Variation of conditions imposed under CM/1/19/PL relating to conditions 2-plans condition relating to external appearance & 3-amendment of wording to remove reference to acoustic metal cladding to south elevation.

Rudford Industrial Estate, Unit J1, J2 & Z Ford Road Ford

Members have noted the substitute plans and that these do not alter Council's original objection repeated again for clarity:

1 SOUTH ELEVATION
SCALE 1:100 @ A1

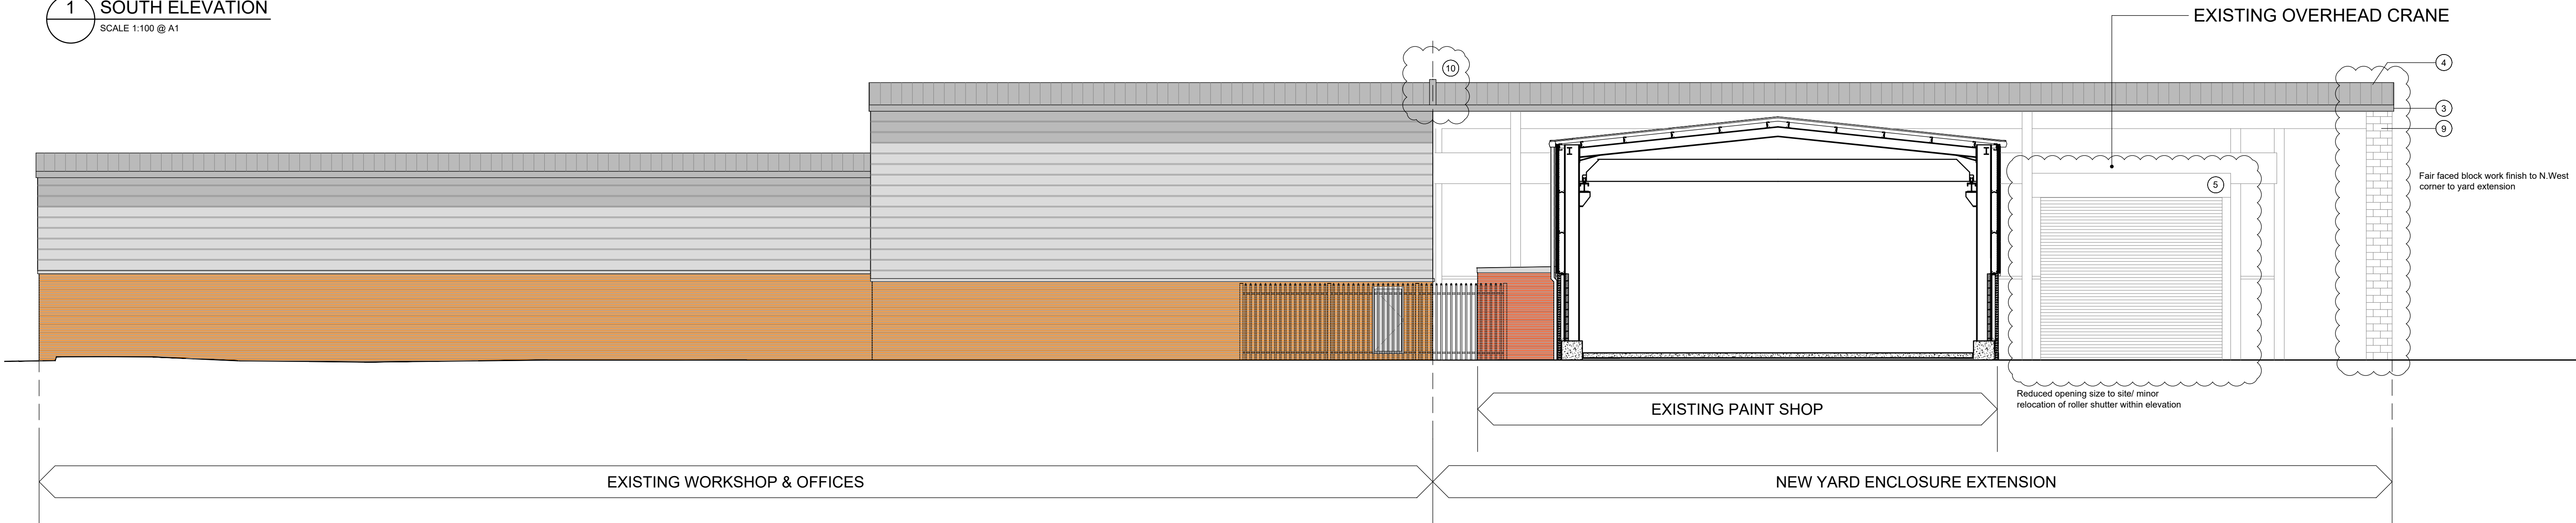
Council objects to the proposal to remove reference to acoustic metal cladding to south elevation as this would be a retrograde step. The condition was imposed to reduce noise pollution and should be retained.
